Application by Indaver Rivenhall Ltd for an Order Granting Development Consent for the Rivenhall IWMF and Energy Centre scheme

The Examining Authority's written questions and requests for information (ExQ1)

Issued on 16 April 2024

Figure 8.1: Sensitive Receptor Locations identified in Condition 38

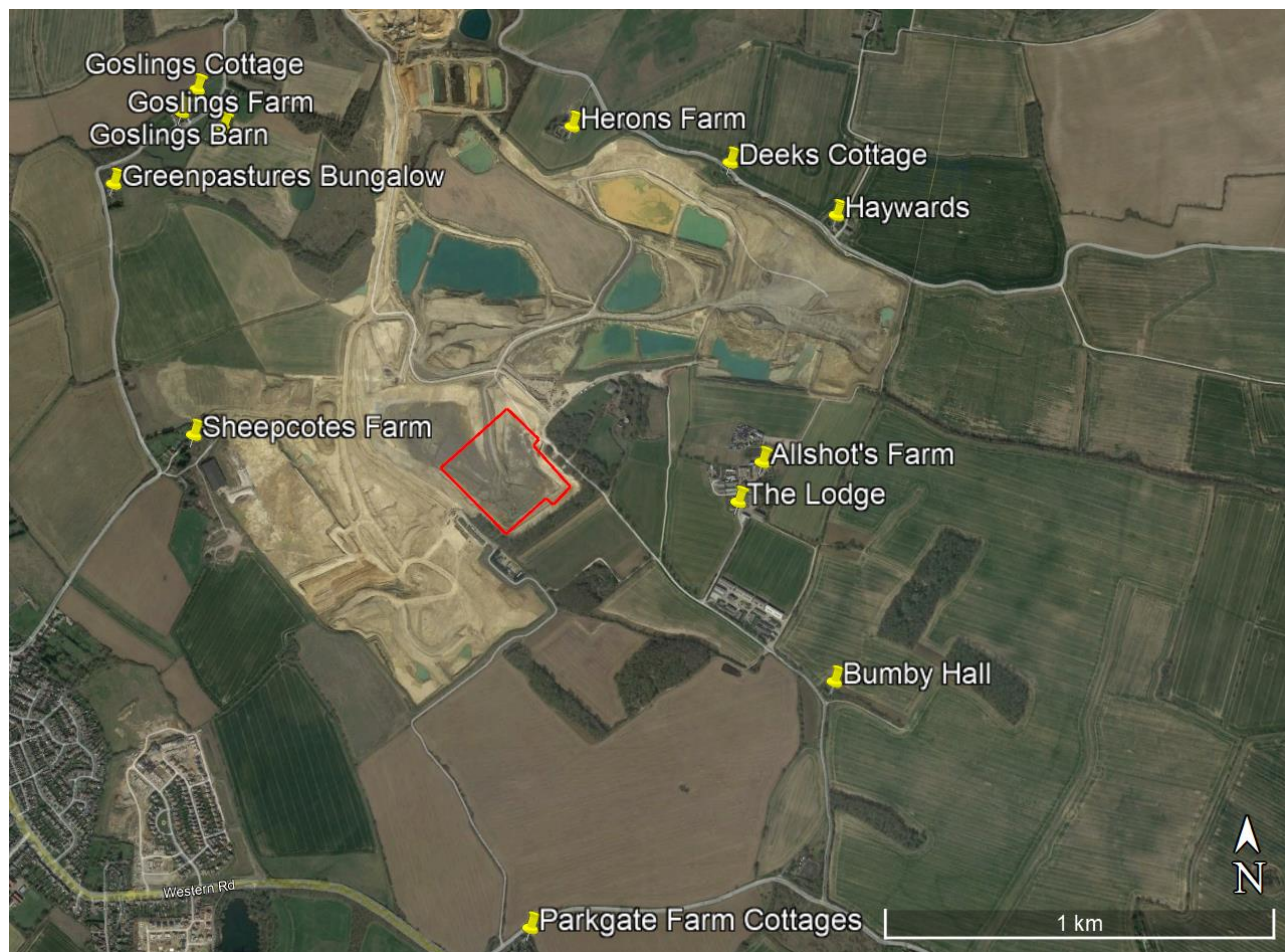
| Q1.6.4 | Applicant | <p>The assessment methodology [APP-033, Table 8.6] sets out that the magnitude of effect is based on the level of exceedance over the noise limits set out in the existing consent.</p> <p>a) Explain why the noise limits were set at the levels that they were in planning conditions 38, 39 and 40 of the existing consent.</p> <p>b) Should the noise limits be considered as maximums not to be exceeded?</p> <p>c) Could any exceedance of the noise limits result in unacceptable effects on the residential receptors?</p> |

Figure 8.2: Predicted Daytime Specific Sound Level at Grid Height of 1.5m – dB(A)

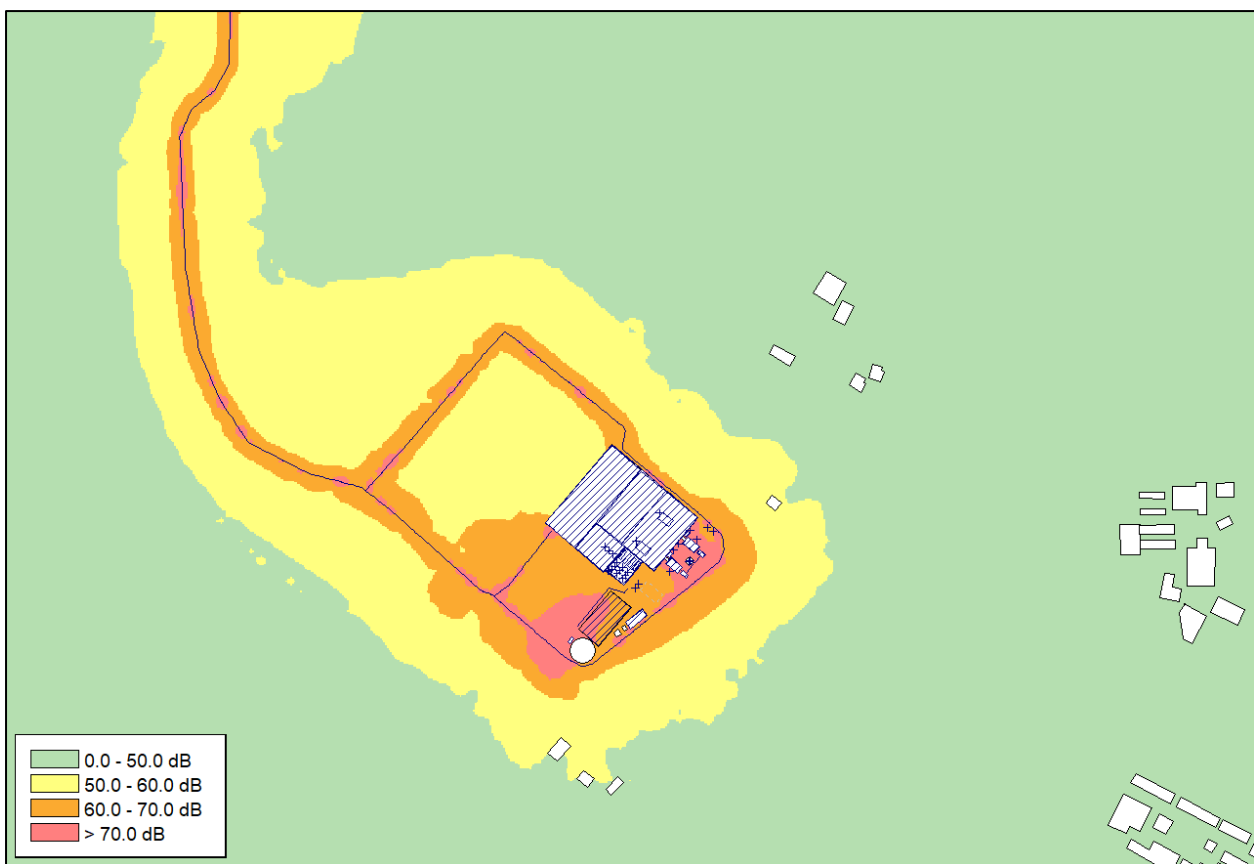
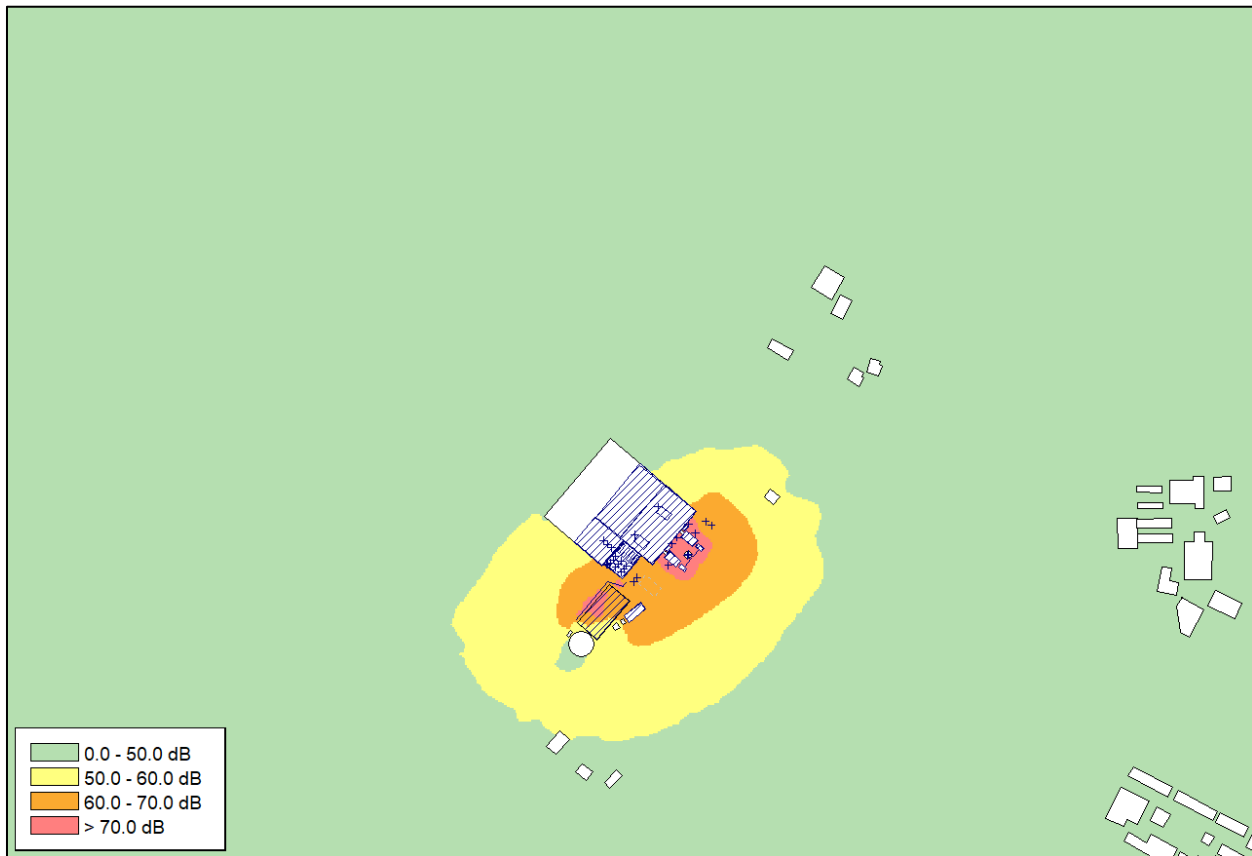
| Q1.6.8 | Essex County Council | <p>Do ECC agree with the modelling inputs and assumptions used in the ES [APP-033, Paragraph 8.6.2] and its appendices [APP-045]?</p> |
